6 February 2018

RMS Reference: SYD16/00625/08

DP&E Reference: SSD7684

**AMENDED CONCEPT PROPOSAL SSD7684 - STAGED REDEVELOPMENT OF COCKLE BAY WHARF - 241 – 249 WHEAT ROAD, COCKLE BAY DARLING HARBOUR**

**COCKLE BAY PARK LANDBRIDGE -
DEMOLITION AND REPLACEMENT OF
THE WESTERN DISTRIBUTOR**

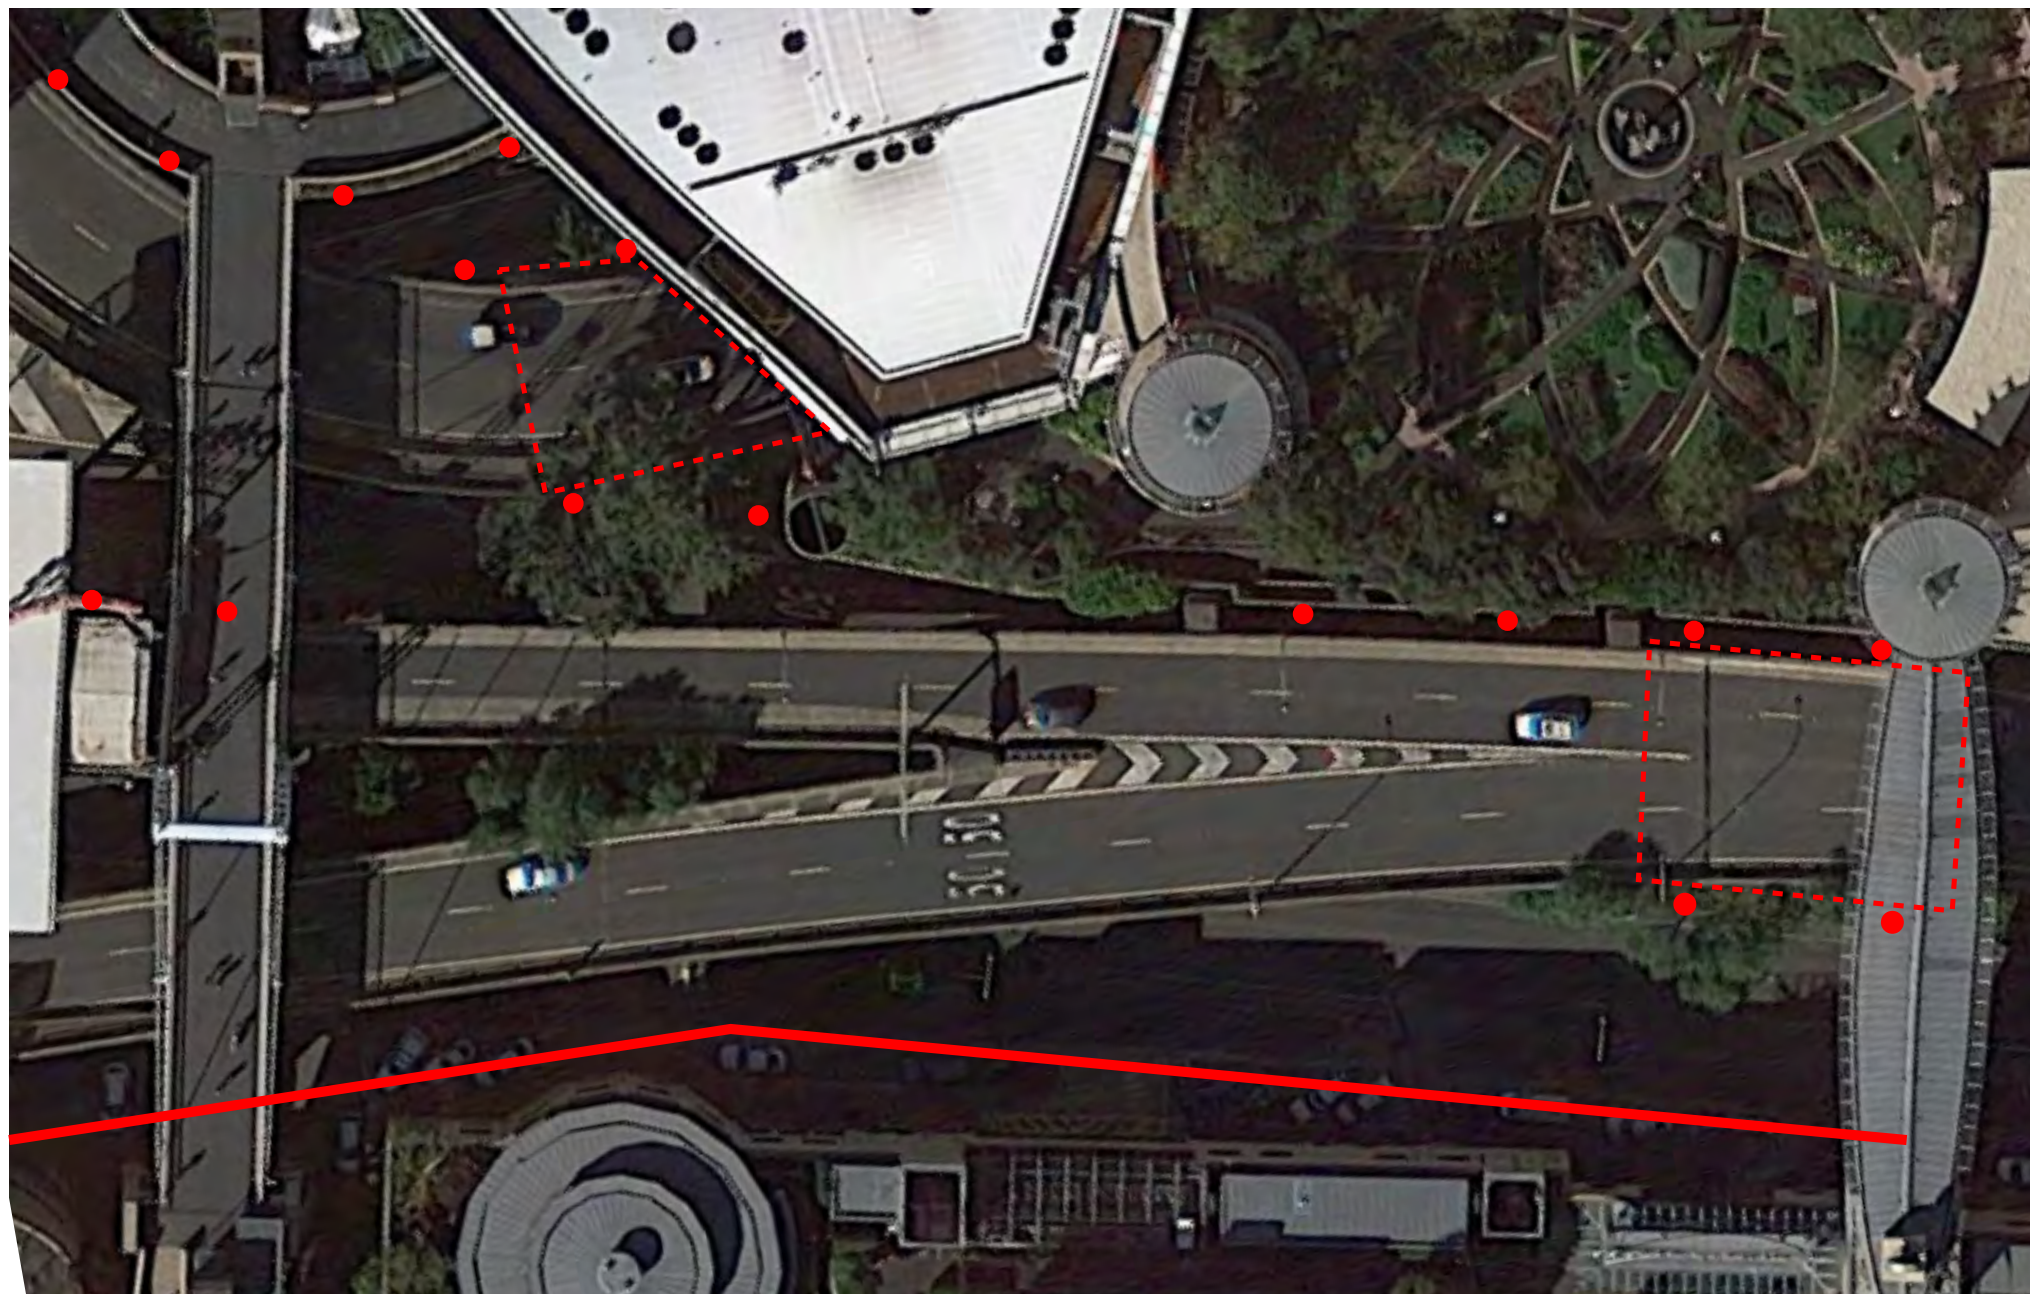
As the proposed development would cover significant areas of the existing bridges, the level of risk to the maintenance of the bridges needs to be assessed. The current proposal is likely to obstruct Roads and Maritime's major maintenance works on Western Distributor bridges B 6794 and B 8565. In this regard, a demolition and reconstruction plan is required.

The demolition and reconstruction plan will need to demonstrate that the demolition and reconstruction of the Roads and Maritime bridges at the end of service life will be possible within the available working envelope following the construction of the Podium. Reducing the size of the Podium land bridge may minimise the risk to Roads and Maritime's assets. This should be investigated in consultation with Roads and Maritime in the preparation of the Stage 2 DA.
